**RE: REVISED ENGINEER'S CERTIFICATION FOR LAS MARCADAS SUBD (C-12/D2B)  
RECEIVED FEBRUARY 3, 1995 FOR FINANCIAL GUARANTY RELEASE  
ENGINEER'S STAMP DATED 9-28-94**

RE: DRAINAGE REPORT FOR LAS MARCADS SUBDIVISION, (C12-D2B), ENGINEER'S  
STAMP DATED JULY 30, 1993

**Re: Tract A-3 Las Marcadas, Traffic Circulation Layout**  
**Engineer's Stamp dated 9-18-03 (C12/D2B)**

**Re: Tract 3A Las Marcadas Subdivision, Golf Course Rd. NW, Grading and  
Drainage Plan**

TRACT A-3, LAS MARCADAS SUBDIVISION
DIMENSION SITE PLAN
ALBUQUERQUE, NEW MEXICO
BLI PROJECT 03521

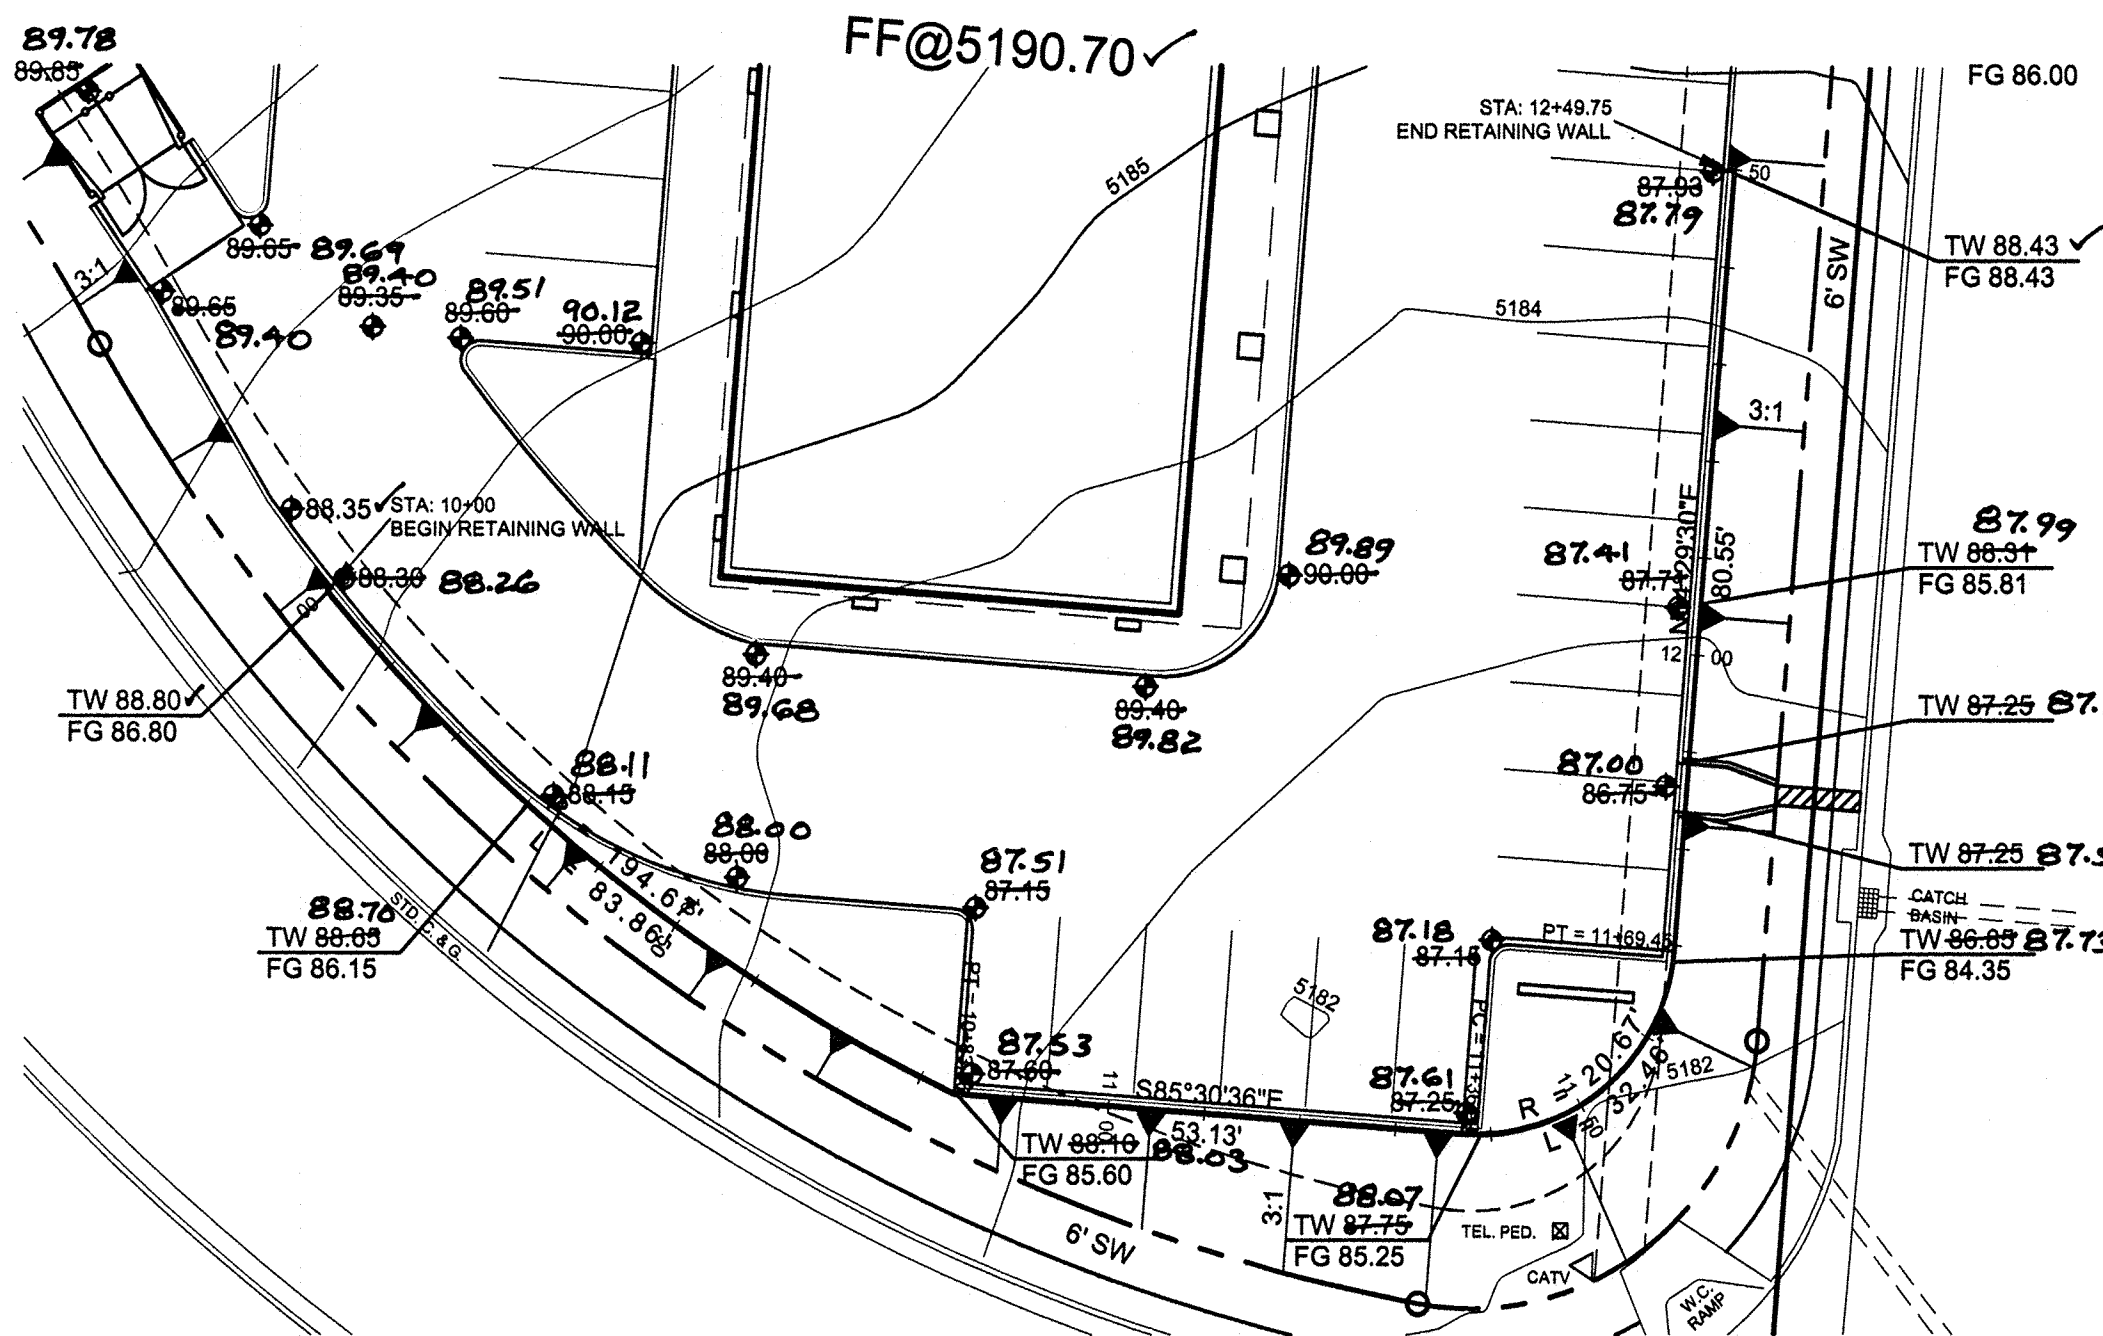
1. Curve 16 will have a radius of 15 feet.
2. The location of the handicap spaces will be revised per zoning.
